Subject: LU/84/21/PL & LU/85/21/L

36 - 38 Surrey Street Littlehampton BN17 5BH

Change of use of premises to a mixed use comprising of 1 No. 4-bedroom HMO unit & retention of 1 No. bed-sit unit at first floor; 2 No. holiday let use units at ground floor with reduction in size of retained hairdressers & ancillary retail storage space & staff facilities to be provided at basement

Drawing Name
Basement, GF and FF Plans - Proposed

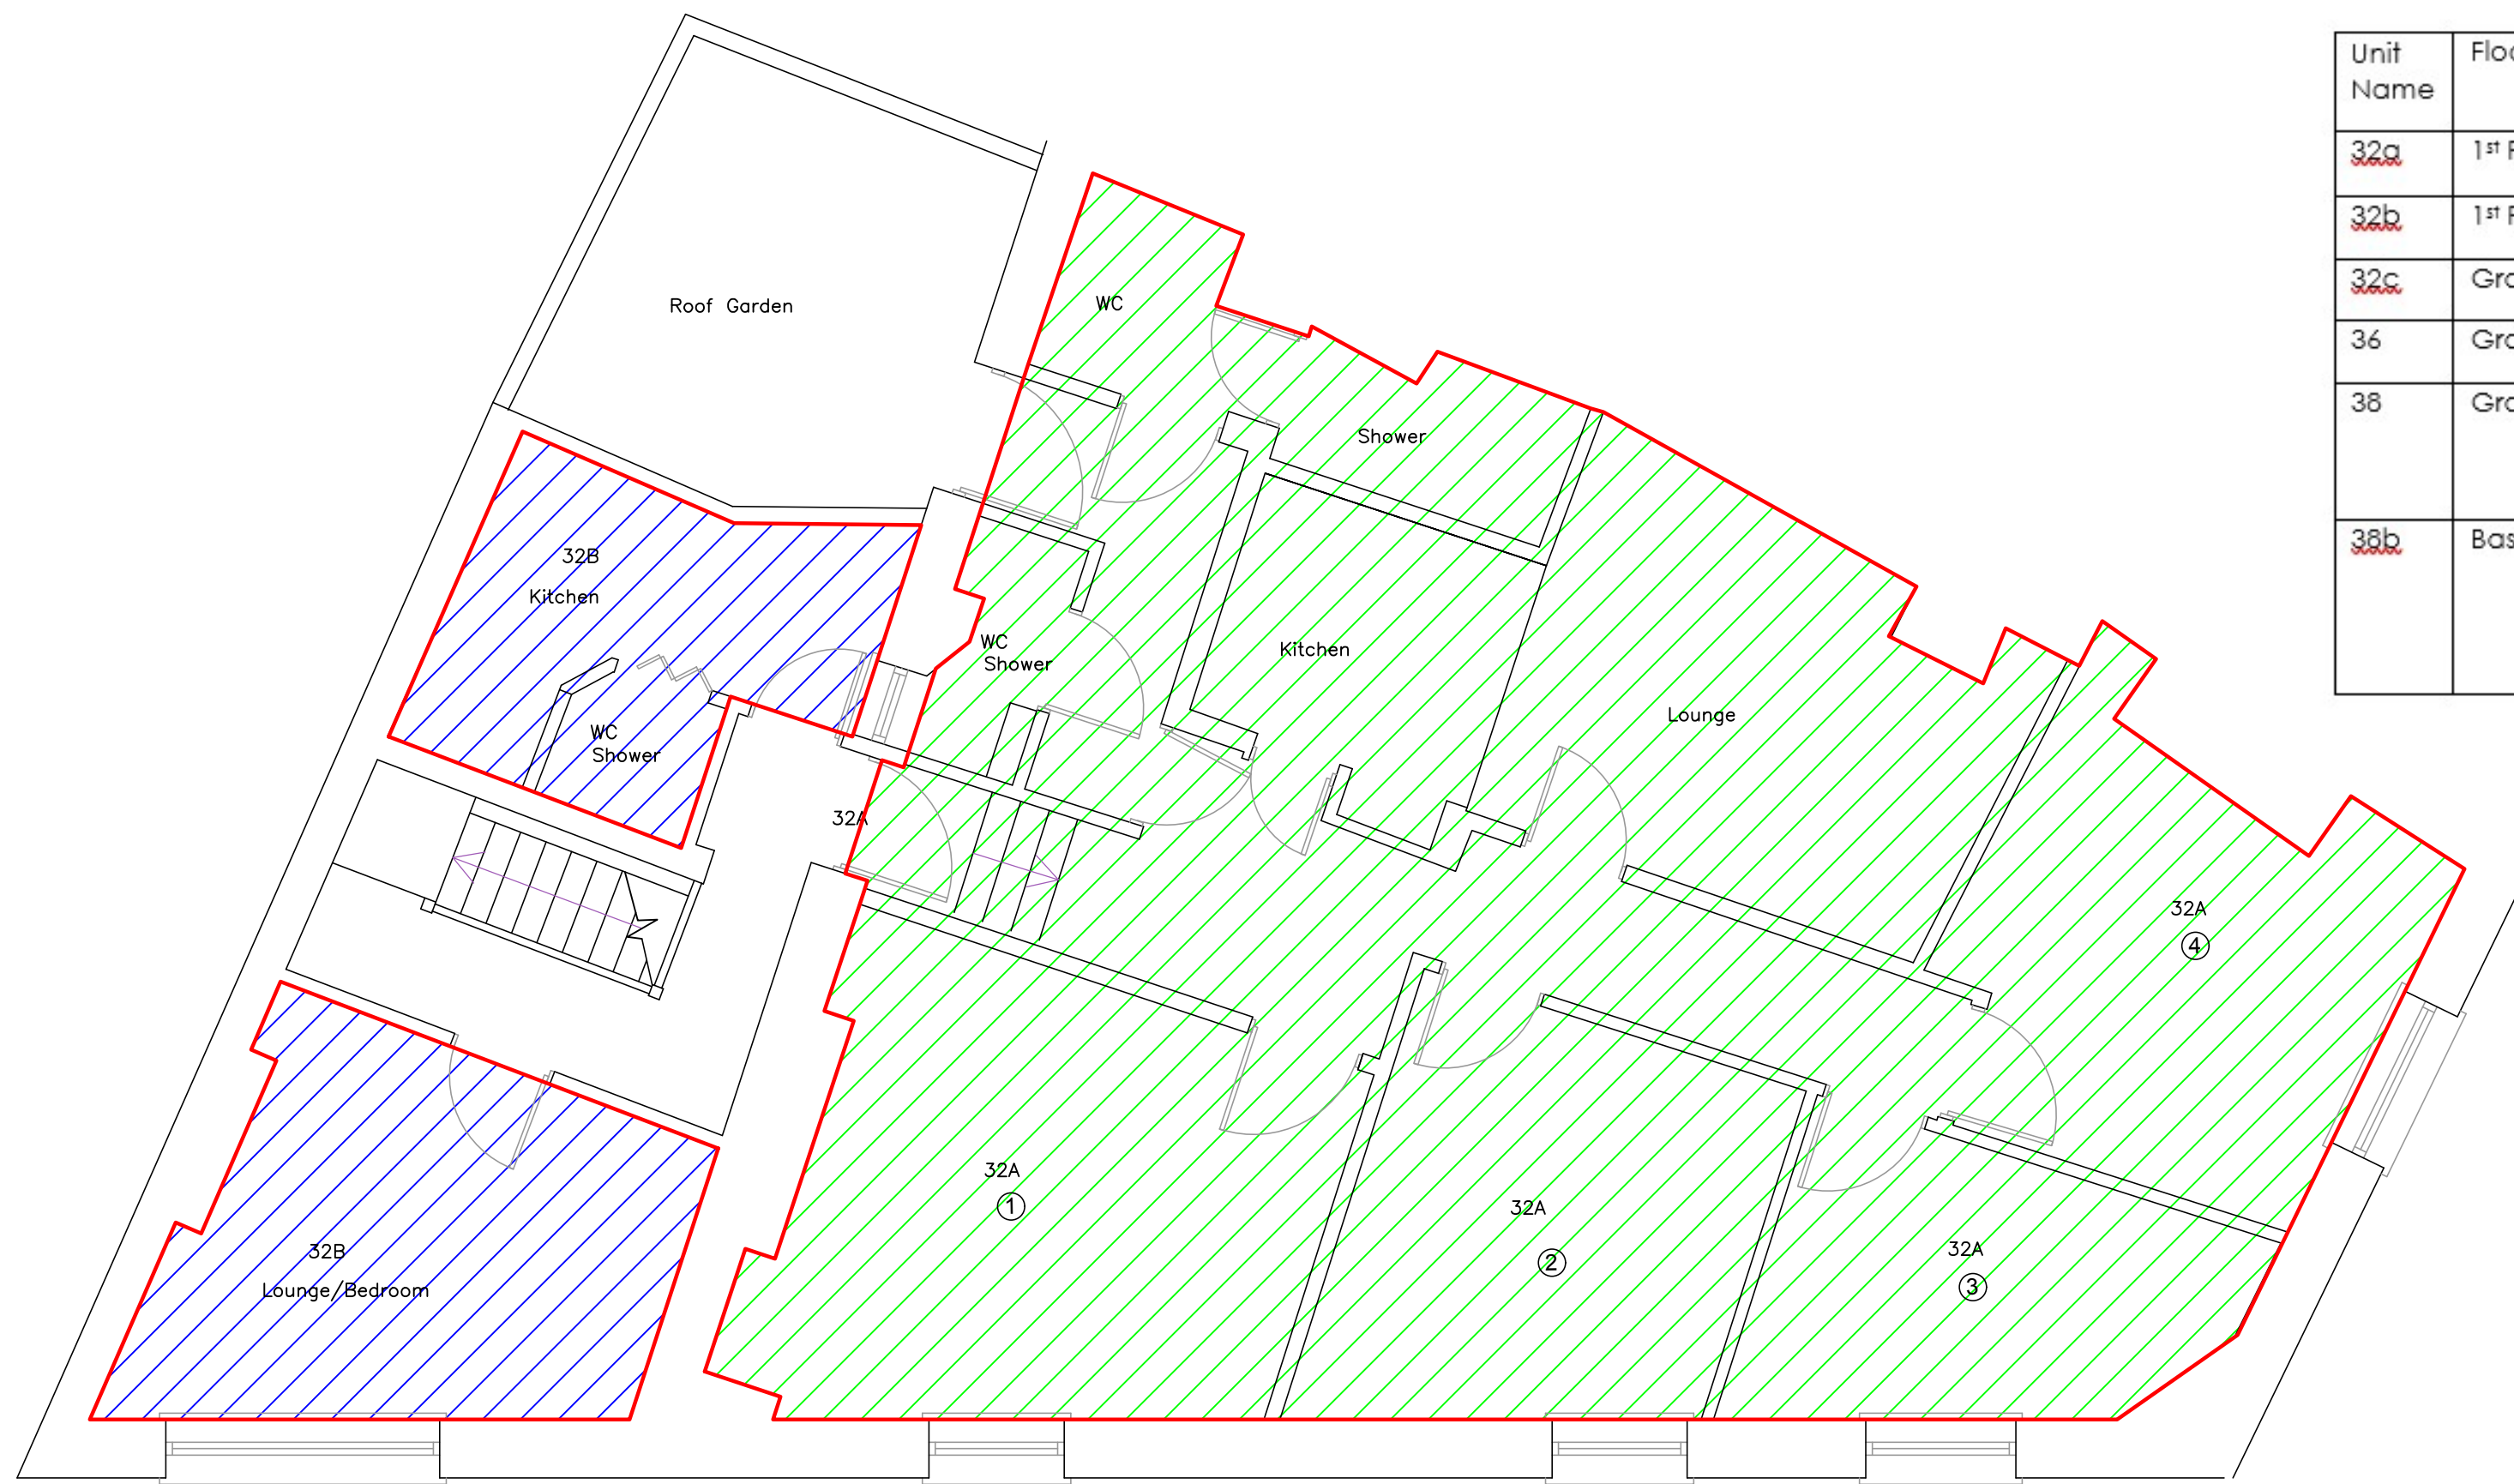
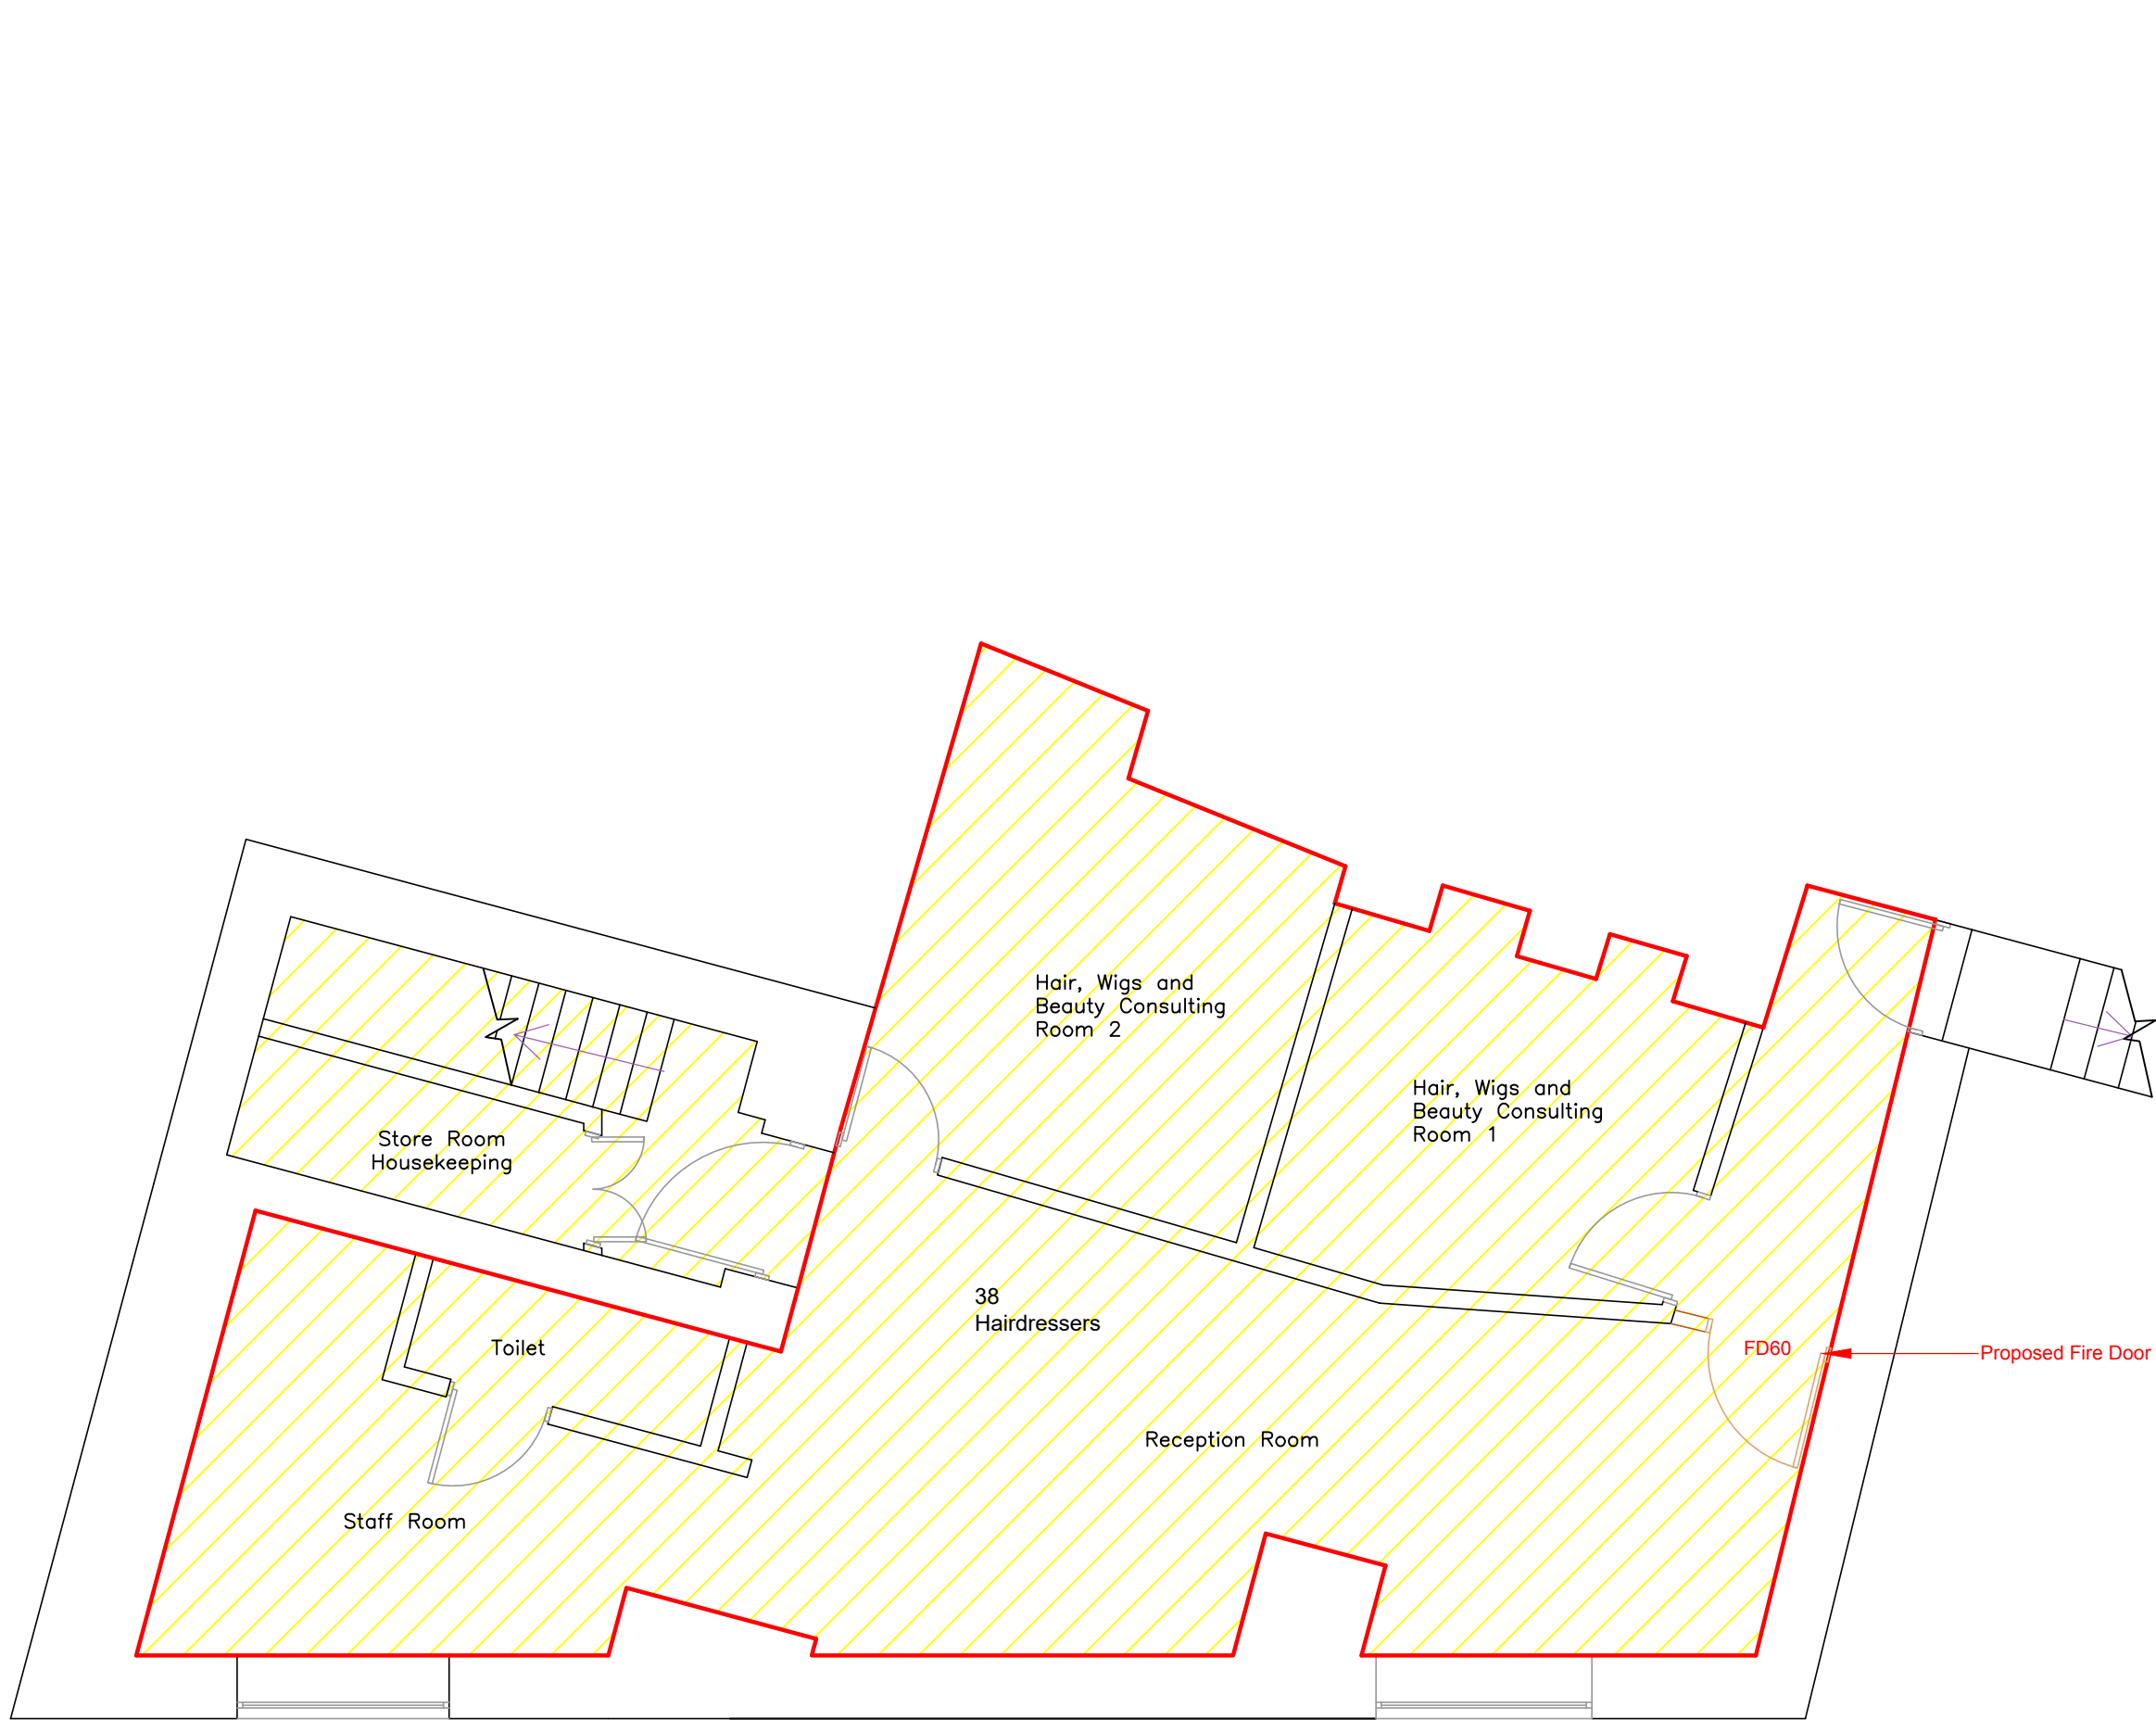
It is evident from looking at the existing and proposed floor plans that a significant amount of internal works have been undertaken in order to accommodate the new uses. As the works are in part retrospective, it is not possible to determine the scale of the impact i.e. in terms of the loss of historic fabric. It is considered that the proposed/implemented floor plan is acceptable as the majority of the floor plan is retained.

It is positive to note that there will be no alterations to the exterior of the building and that the Surrey Street frontage will maintain an active, commercial use.
